**Harnett County**  
420 McKinney Pkwy  
LILLINGTON, NC 27546  
Phone:  
Fax:

SUBJECT: **BRES2407-0034**  
**BUILDING RESIDENTIAL**

Here are the results of all Inspections located at **121 STEWART FARM LN:**

FOUNDATION PLAN
SCALE : 3/16" = 1'-0"

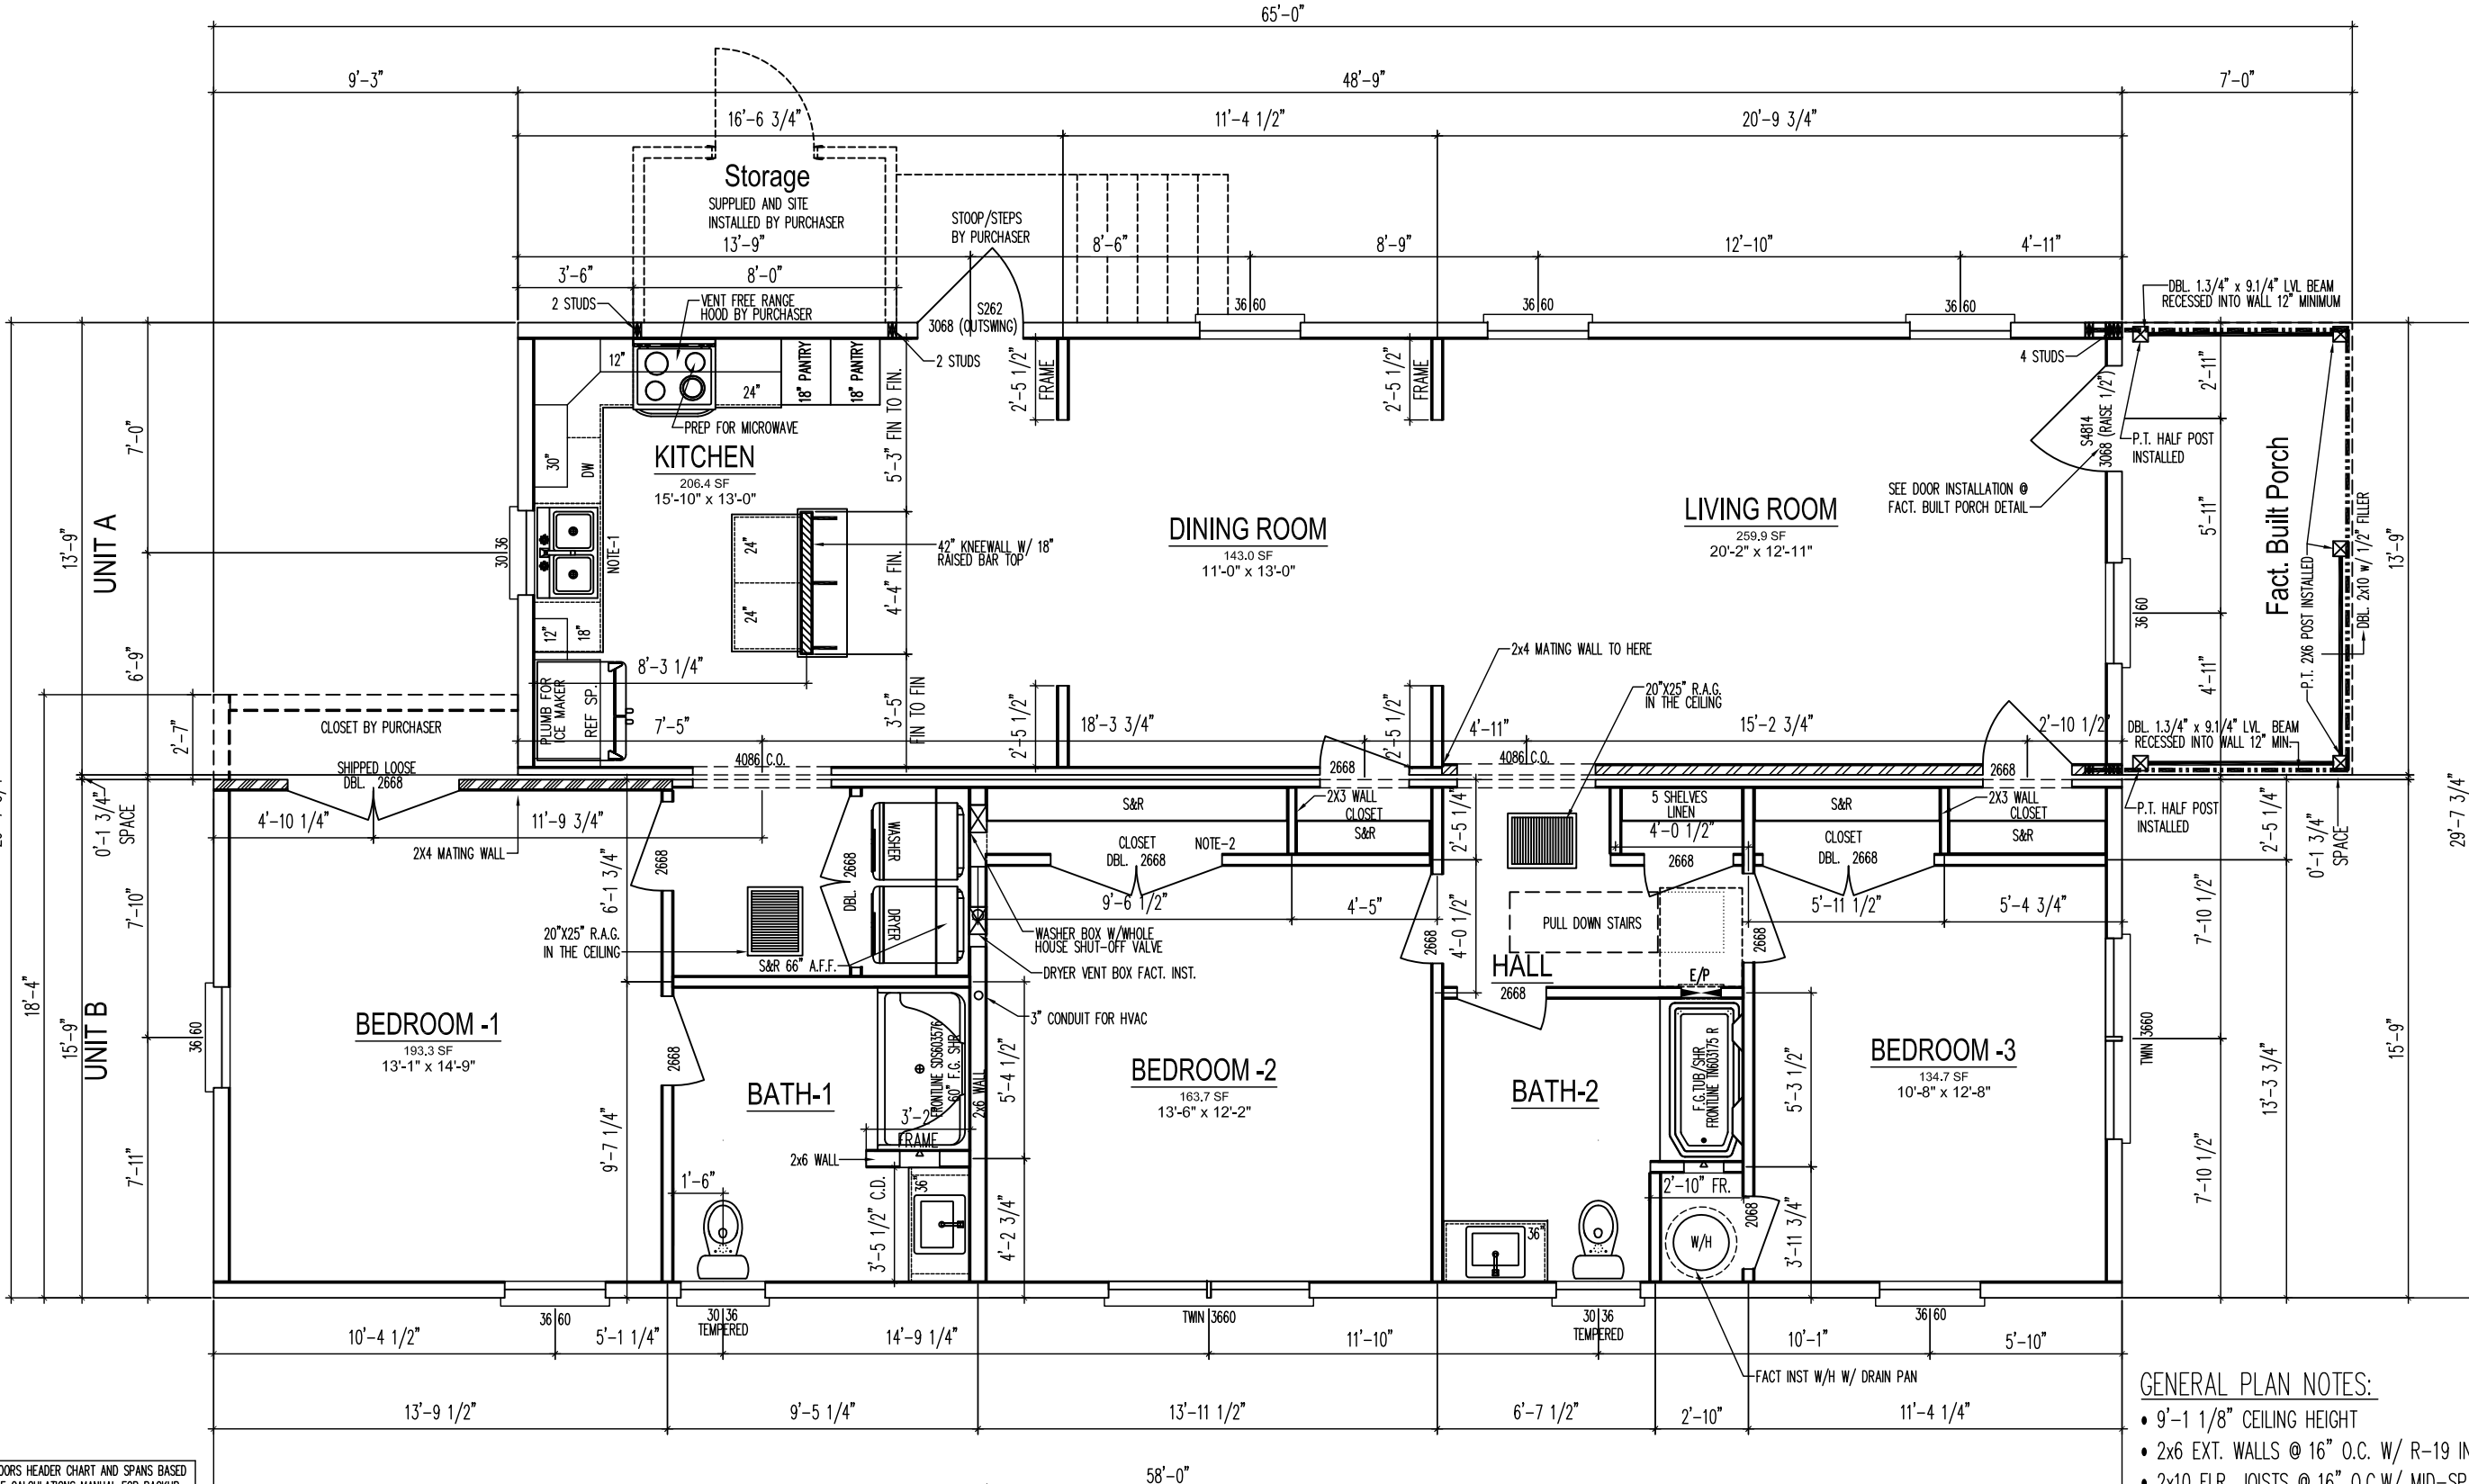
Notes: Top of footing must be exposed for foundation inspection to verify bed joint and projection.

Notes: Uncover footings on foundation walls and piers inside and out for inspection
